Peak District National Park Authority

Our ref: PE\2026\ENQ\53951

RE: 2026/91359- Erection of agricultural building and access track at Moss Edge Farm, Moss Edge Road, Holmbridge, Holmfirth, HD9 2SD.

Drawing Title PROPOSED SITE LAYOUT

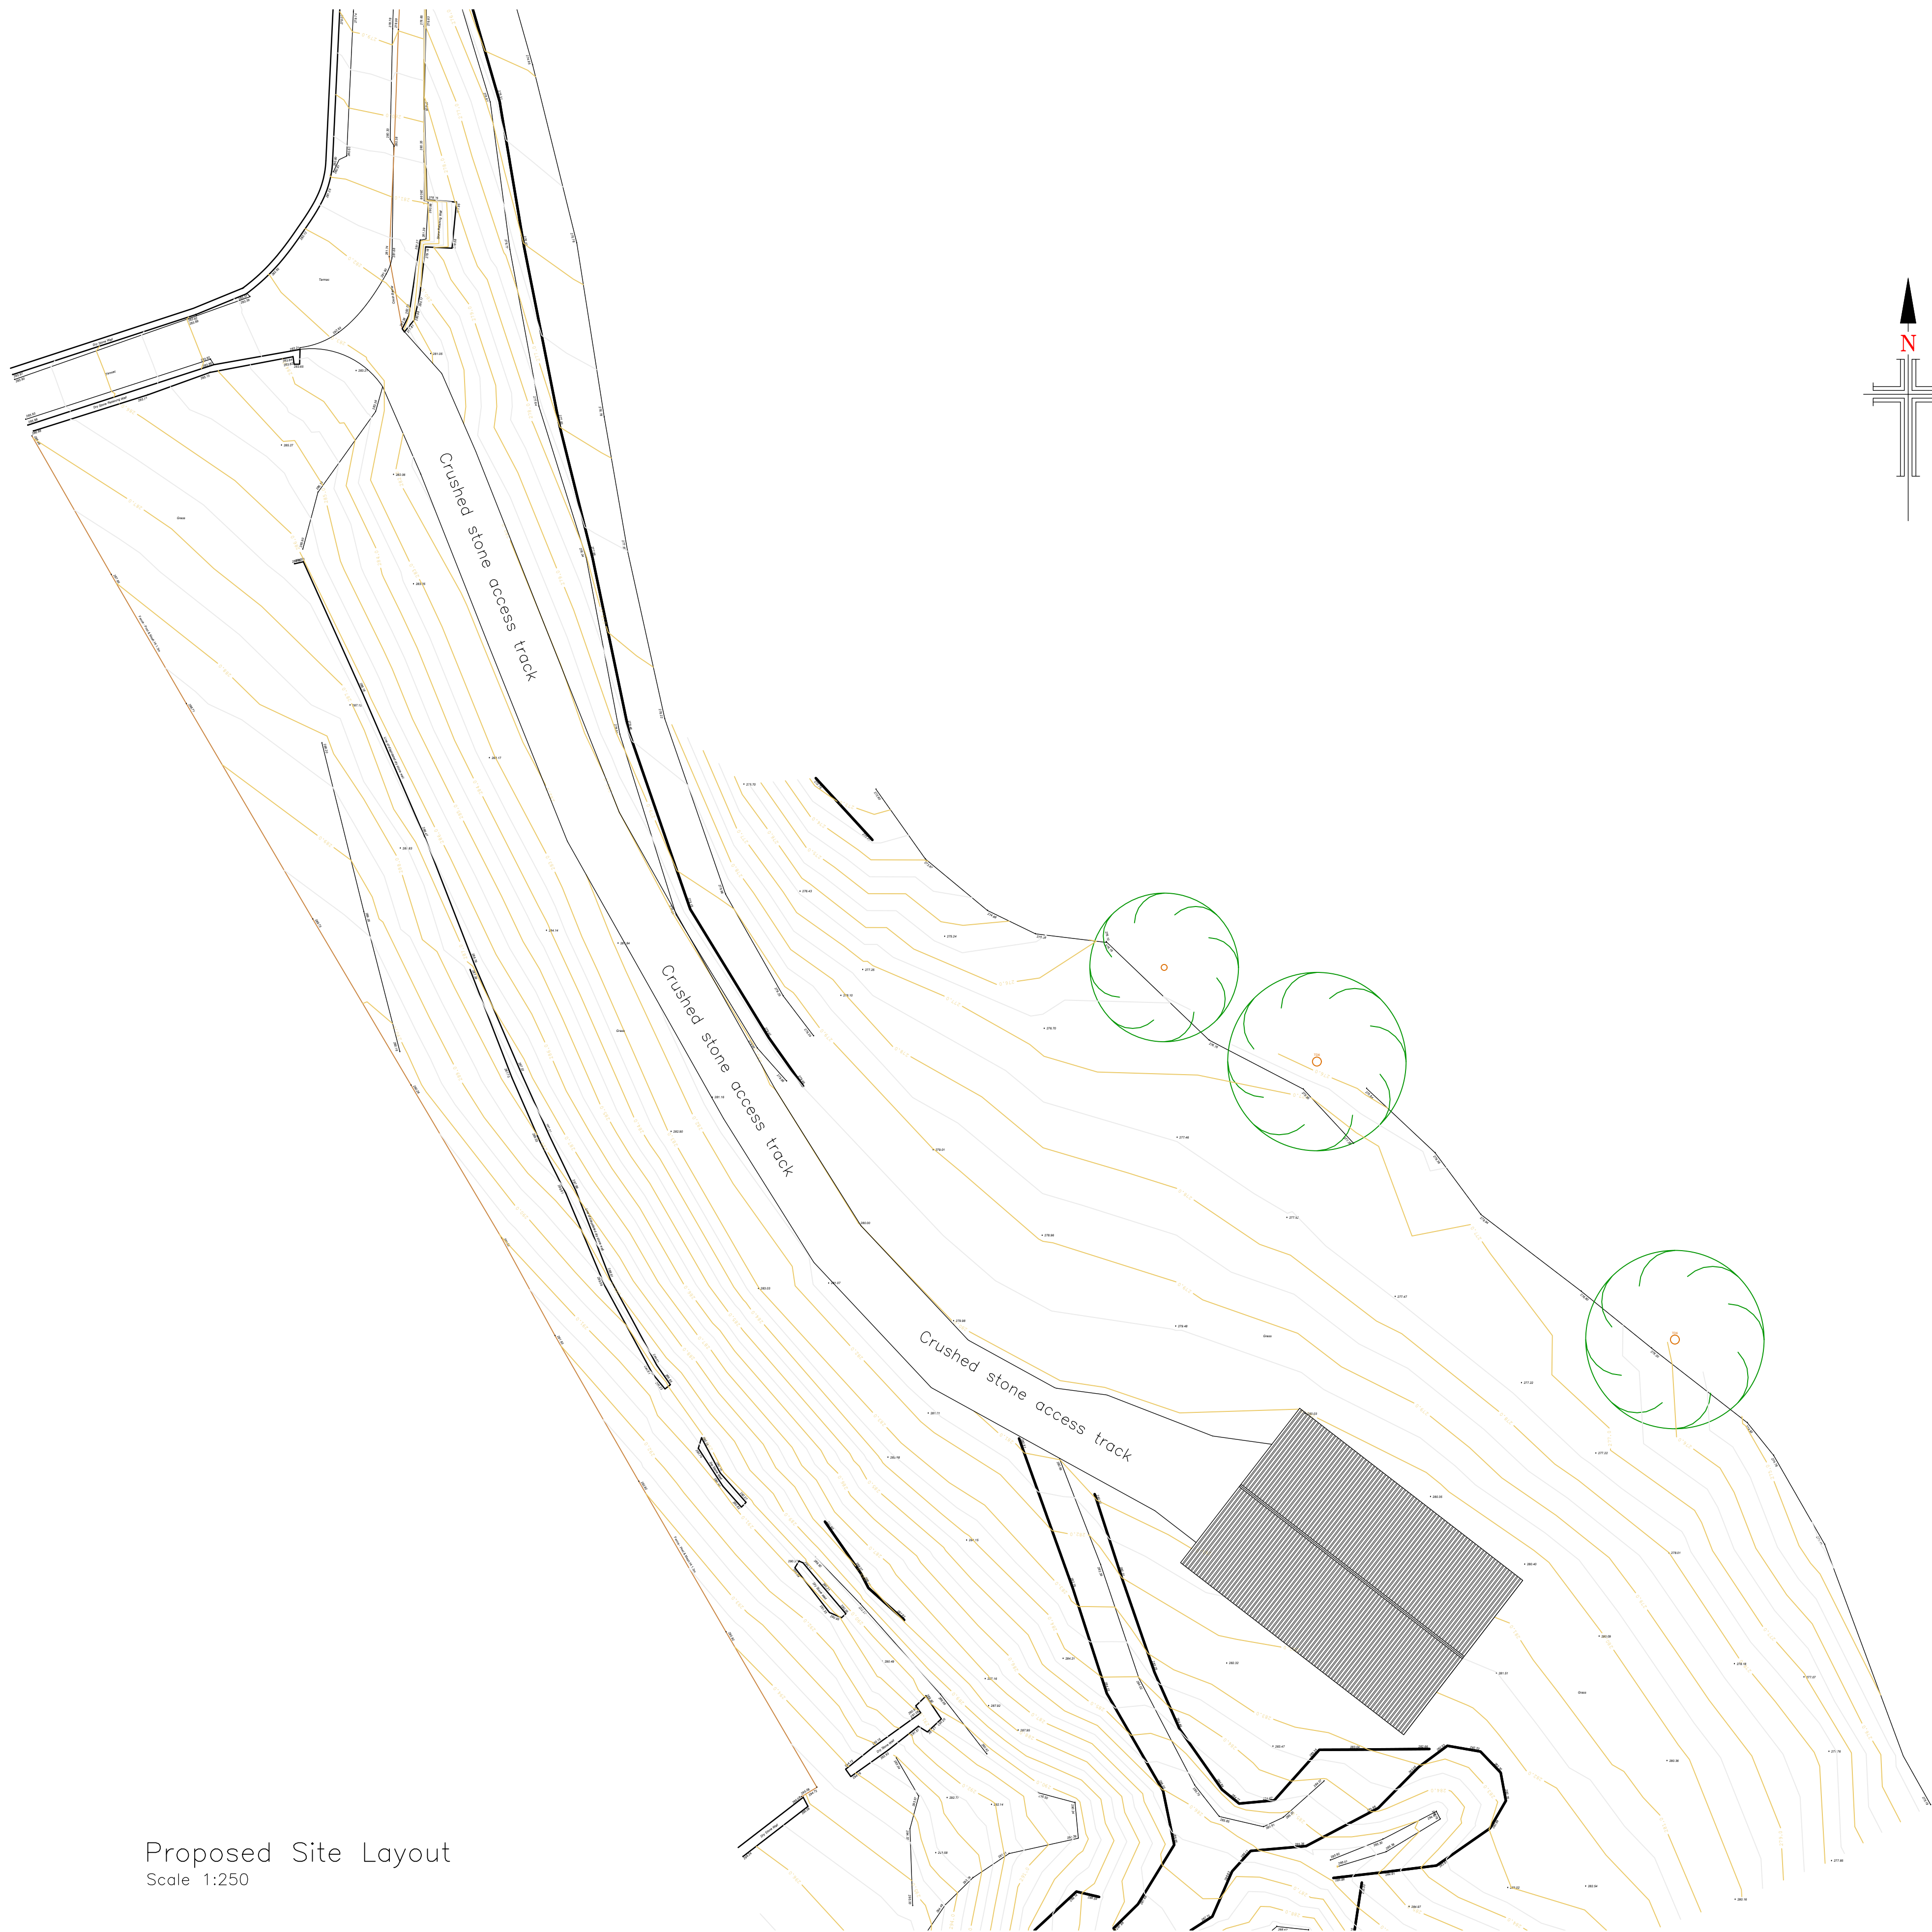
The development proposed is approx. 550m from the boundary of the National Park. The building proposed is not within an existing farmstead and therefore would not align with the National Park Authority's policies for new agricultural buildings in this respect and it is unclear why the proposed building cannot be sited closer to the existing farmstead which would provide access to services, water and, during lambing, would allow for closer observation. This would also remove the requirement for an additional track across the natural landscape.

It is also unclear how close the building is sited to the ancient woodland -Moss Edge Wood- and although outside of the National Park, any impacts to the woodland could erode the visual, wildlife and biodiversity benefits on its boundary.

If the application is to be approved, we would urge careful consideration of any external lighting if this is deemed required as it could potentially impact the dark skies and natural environment in this rural area.
